Recommendation Report for Lawful Development Certificate for a Proposed Use or Development**REF NO:** BN/15/21/CLP**LOCATION:** 58 Downview Road
Barnham
PO22 0EF**PROPOSAL:** Lawful development certificate for the proposed use of existing cabin ancillary to house for private use and short term lets.**DESCRIPTION OF APPLICATION**

FLOOR PLAN

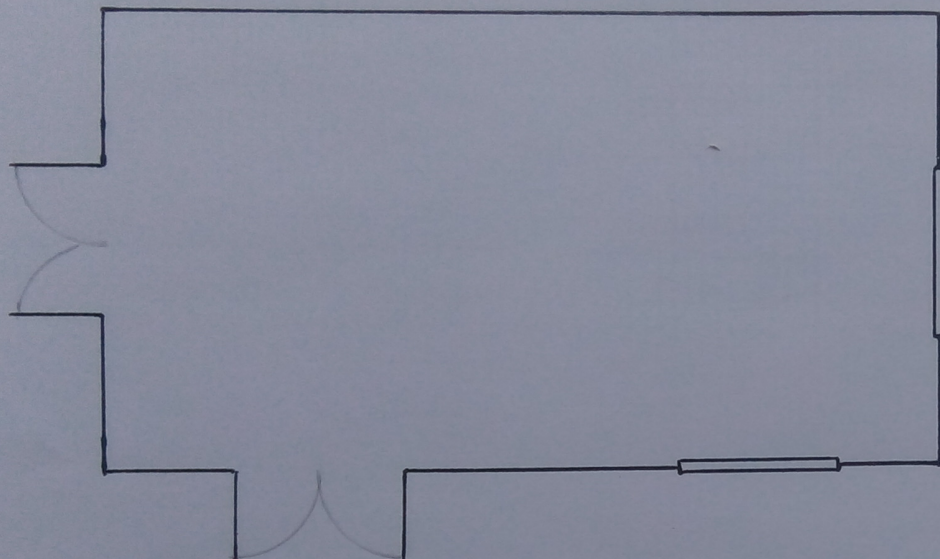
The height of garden cabin, as shown on the submitted documents, is 2.7m within 2 metres (0.85m) of the boundary of the curtilage of the dwellinghouse, as such it would not be permitted by Class E, criterion e),(ii).

The garden unit is self contained and has all normal facilities for day-to-day living therefore it is considered that the proposed use fails to be an ancillary to the main house.
